Recommendation Report for Planning Permission for Works or Extension to a Dwelling

REF NO: FP/10/21/HH

LOCATION: 68 Downview Road
Felpham
PO22 8JA

PROPOSAL: Single storey front porch extension and first floor extension over existing garage (Resubmission of FP/196/20/HH)

sheet 1 a of 3

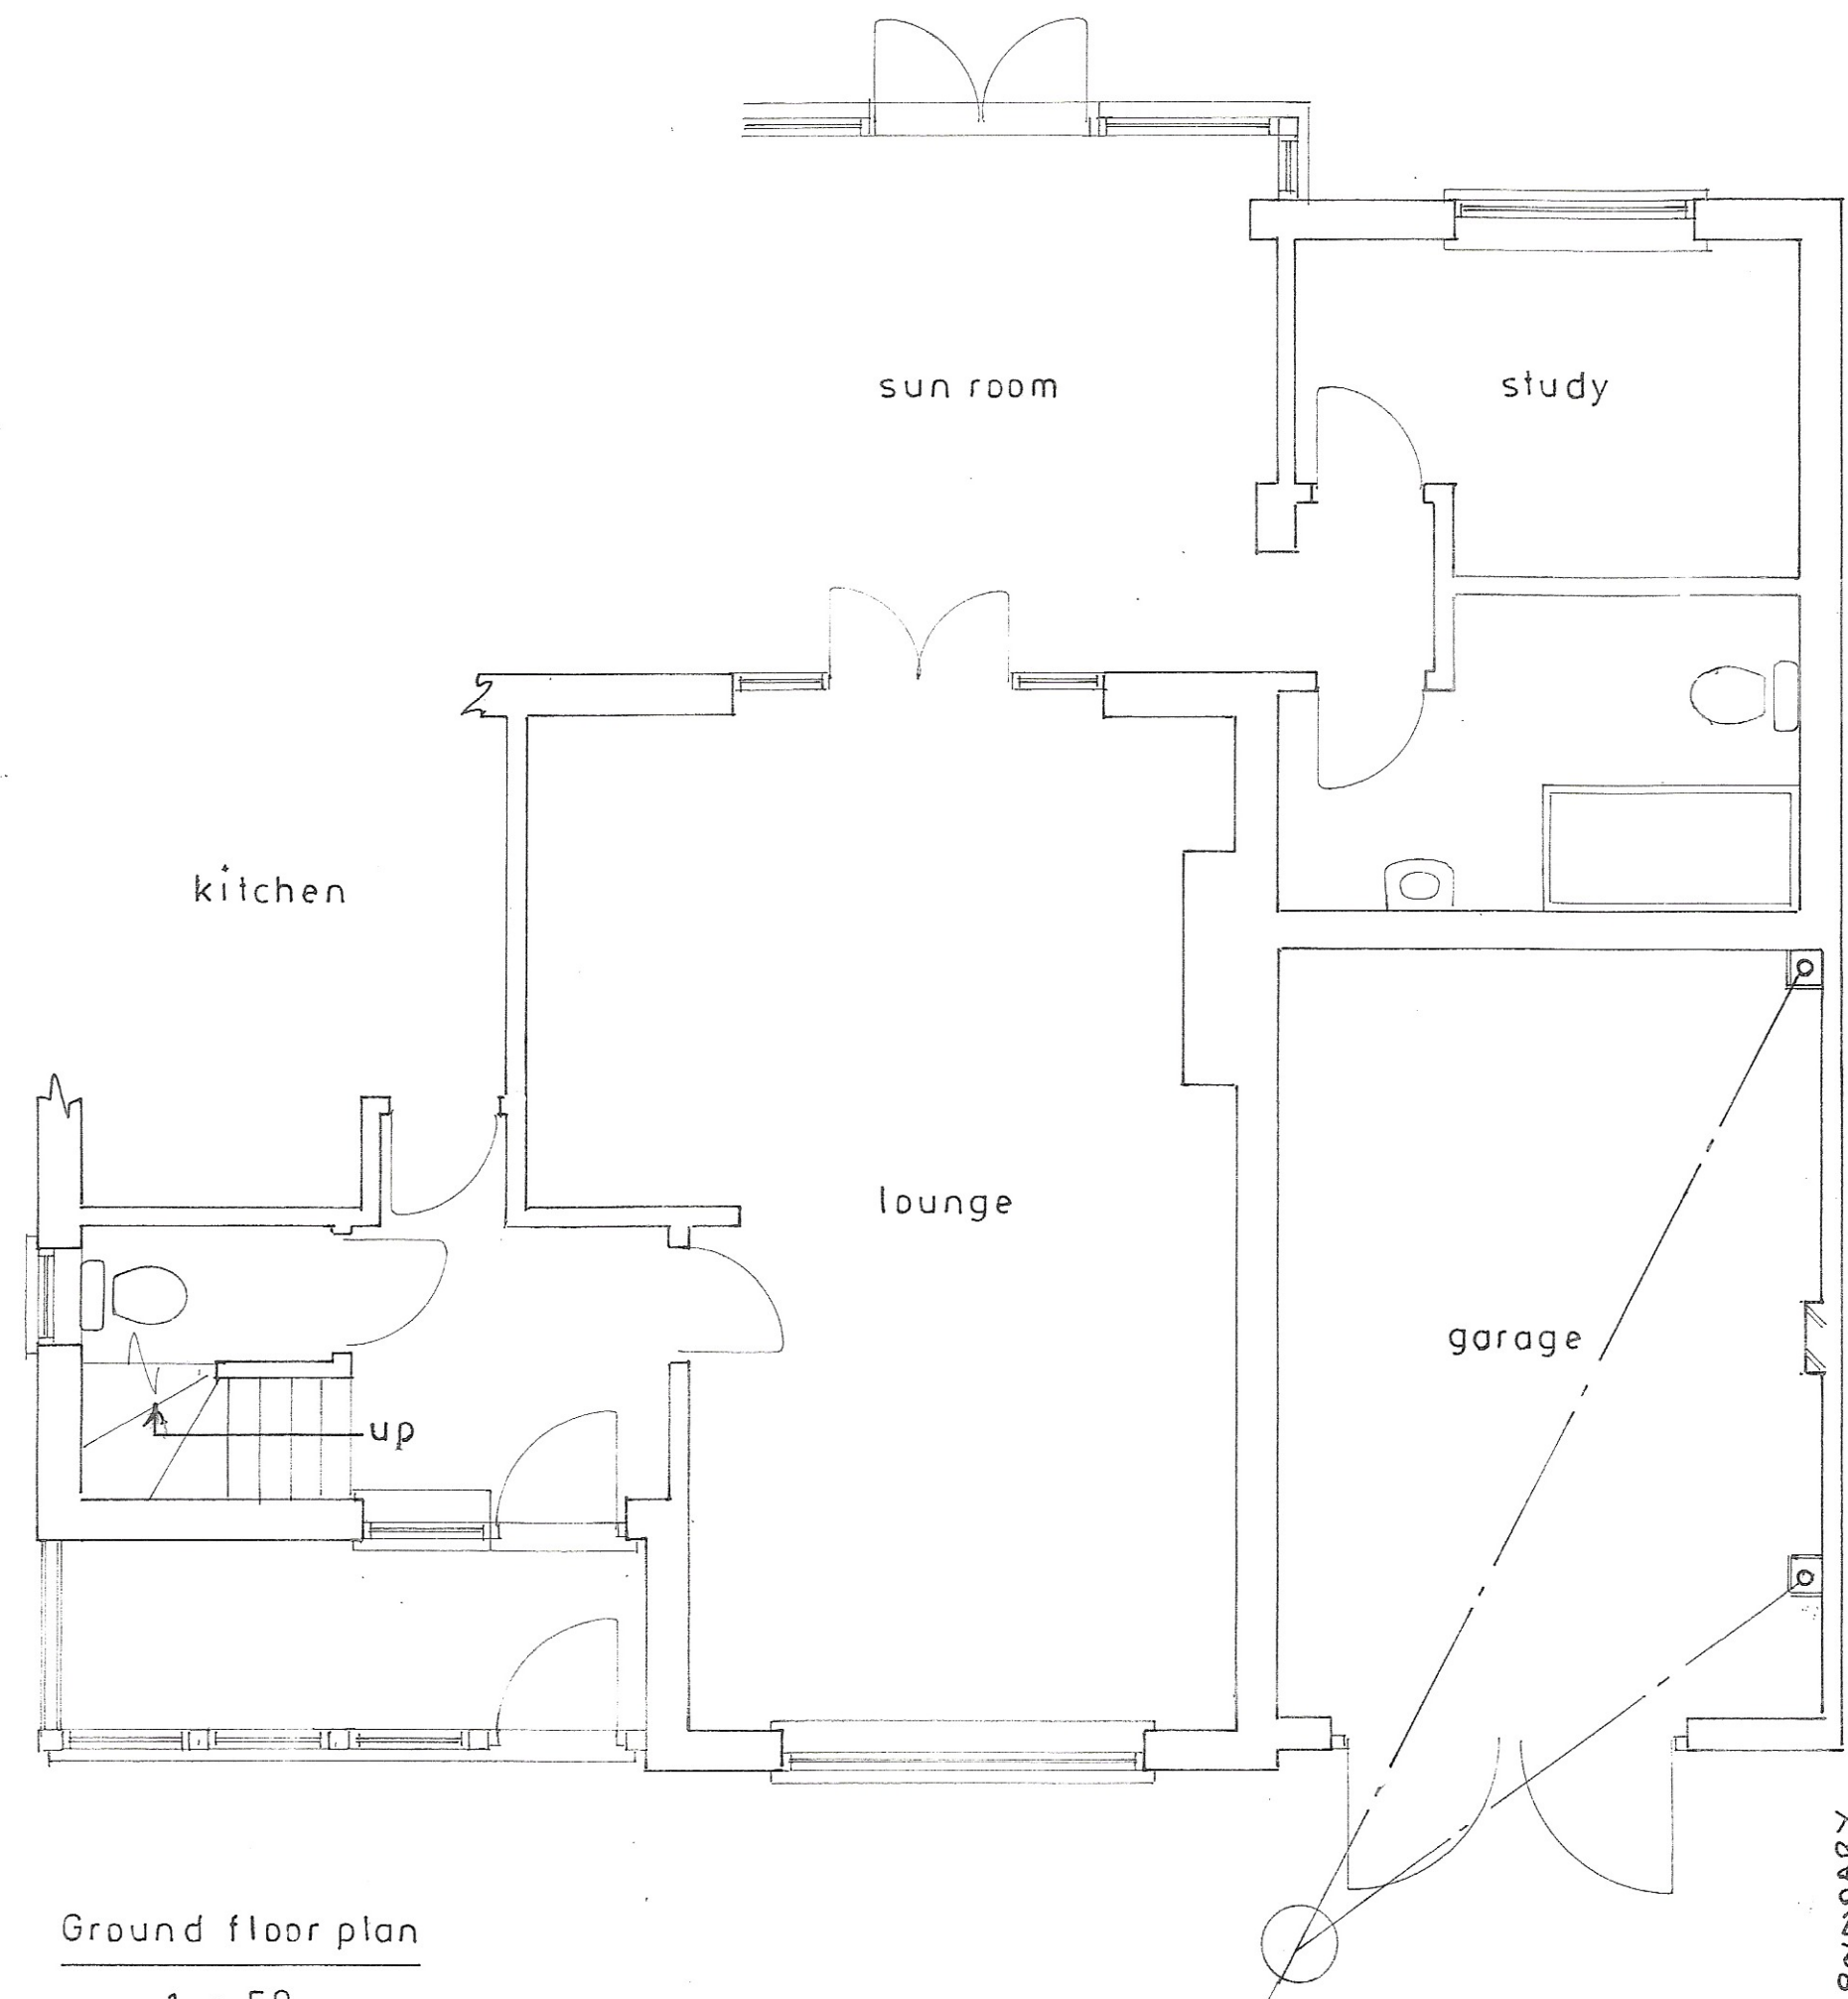
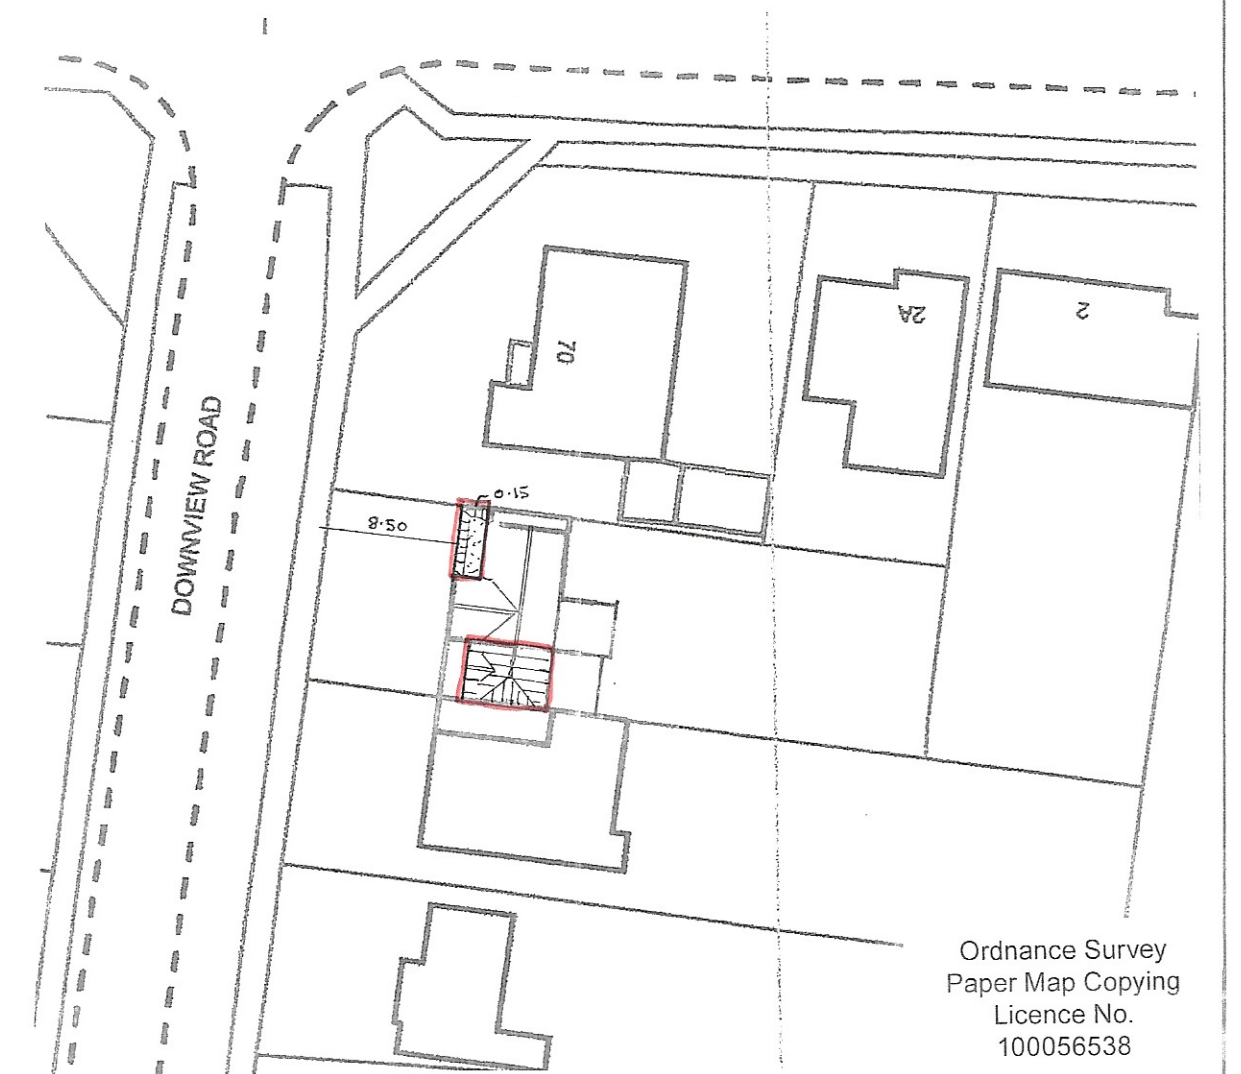
There will be a front porch to the west elevation with a width of 4.2m and depth of 1.6m. This is smaller in scale with a flat roof and considered acceptable.

sheet 2 a of 3

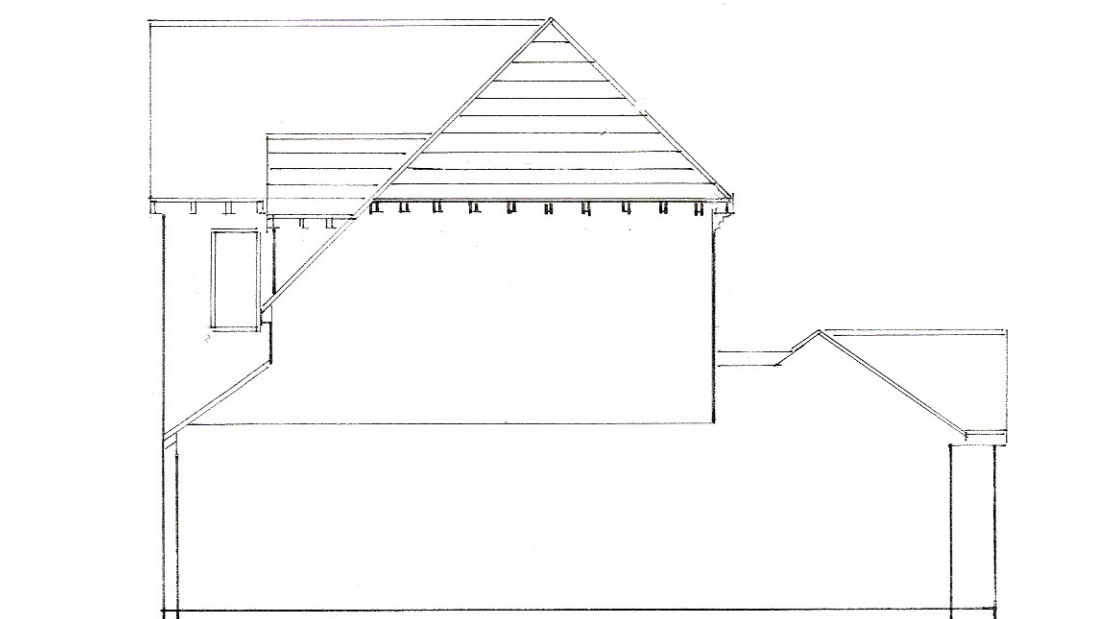
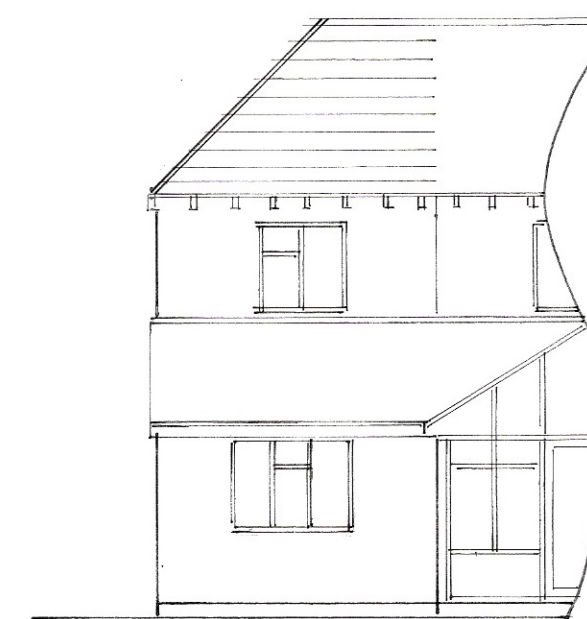
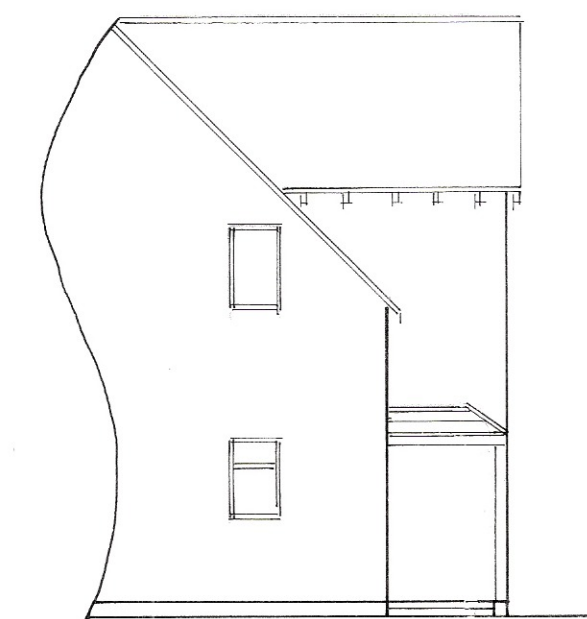
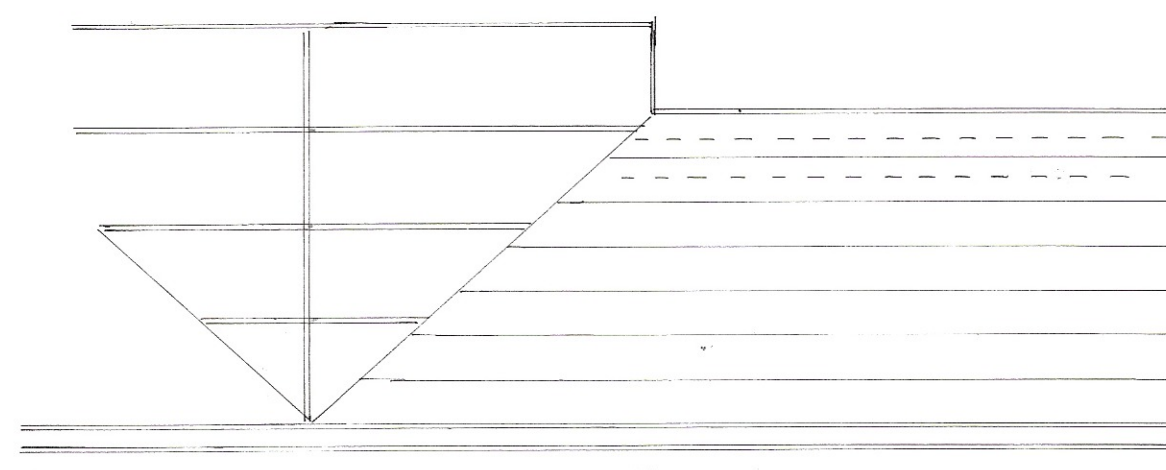
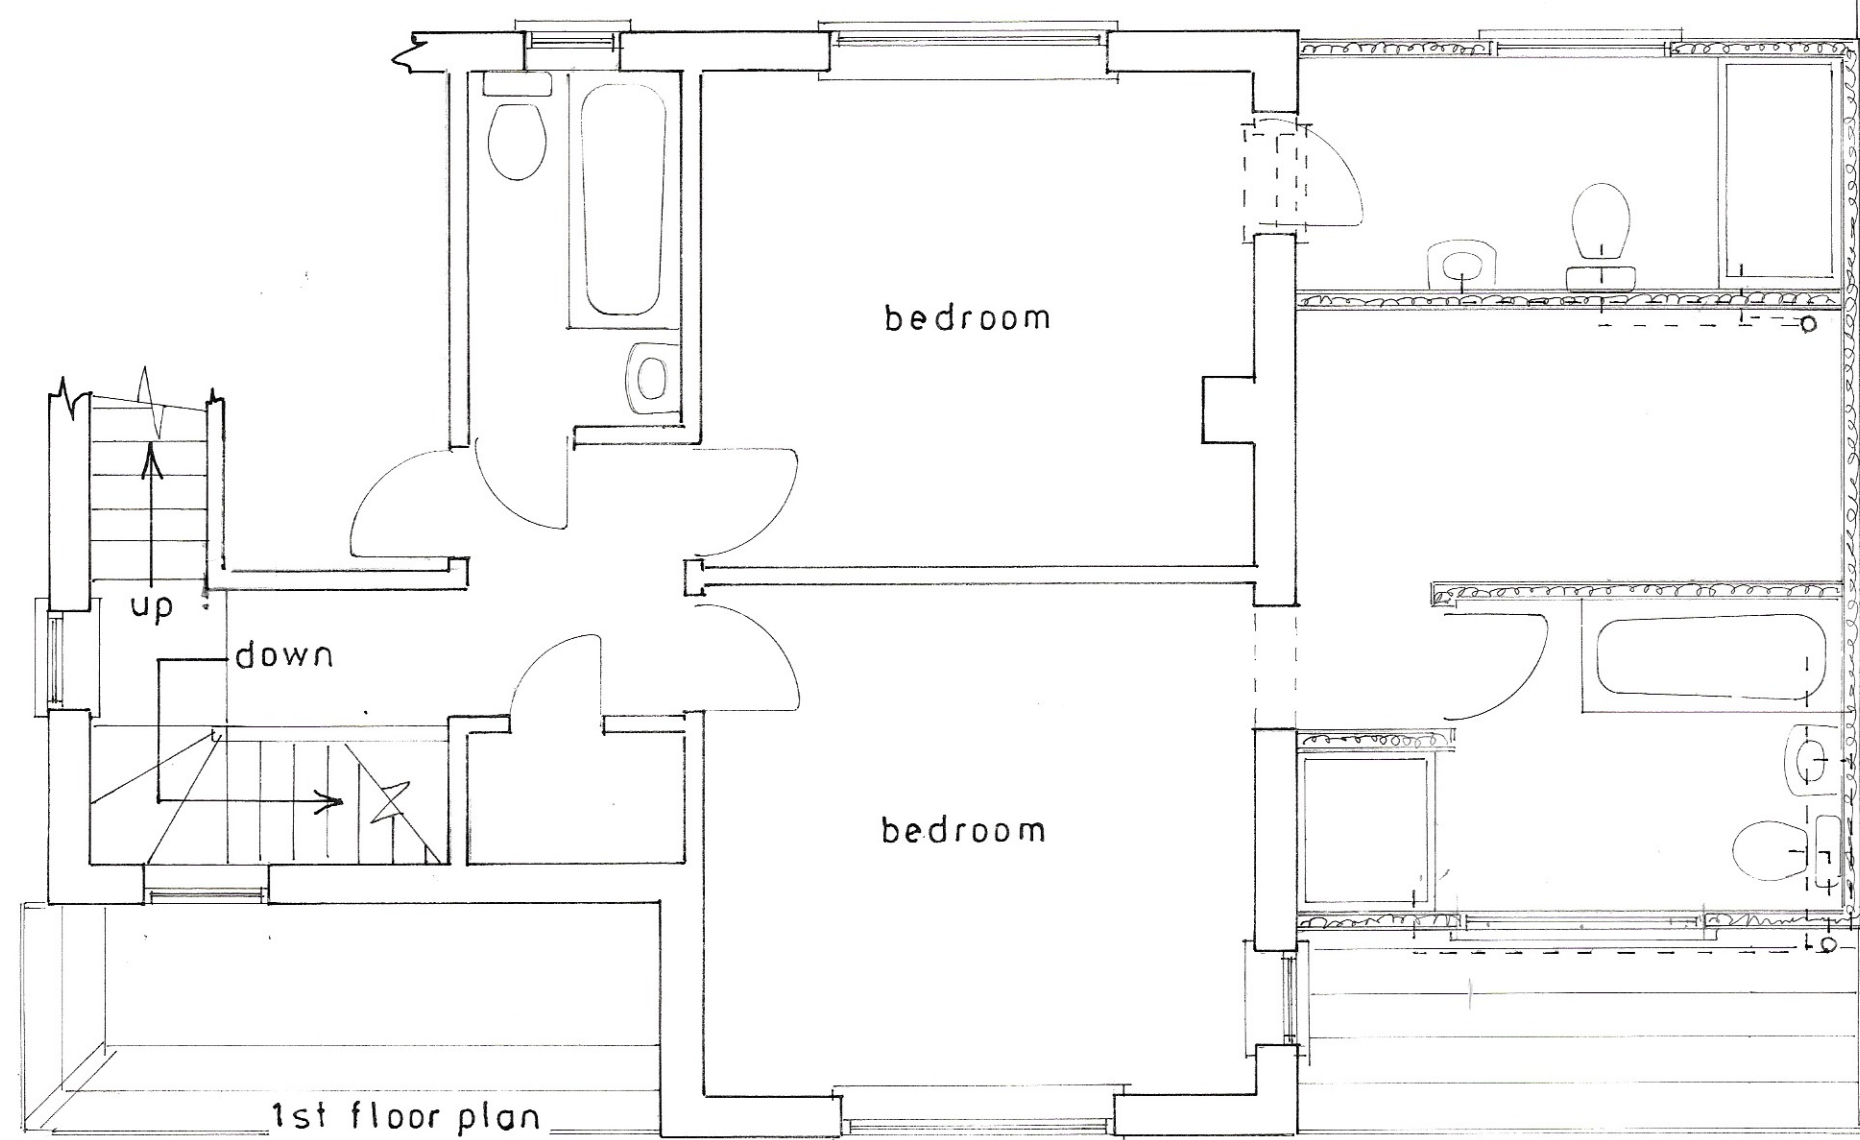
The property has a garage to the side elevation and this will be extended 5.25m in height allowing a first floor to be added which will run alongside the southern boundary with a depth of 5.9m. The extension will have a height which matches that of the ridge of the existing dwelling.

The extension to the top of the garage will have a hipped roof and will abutt the side boundary.

Due to the size, the proposal adds additional bulk to the side elevation and as a result of the siting of the neighbouring property at No.66 which is located parallel to the host dwelling, it is considered to result in an oppressive and overbearing effect on the amenity no 66 including that of the first floor dormer. The two storey addition will have a significantly detrimental impact on the occupiers at No.66 due to the bulk and proximity resulting in an unneighbourly form of development.

As a result of the siting and size of the development, it is deemed to give rise to unacceptable adverse overbearing impact upon the occupiers at No.66 and as such is in conflict with D DM1 (3) and D DM4 (c) of the Arun Local Plan. Policy ESD1 of the Neighbourhood Plan states that development should be 'appropriate to its location'. The proposal is in conflict with this in so much that the size of the development is not appropriate for its locality abutting the boundary with No.66.
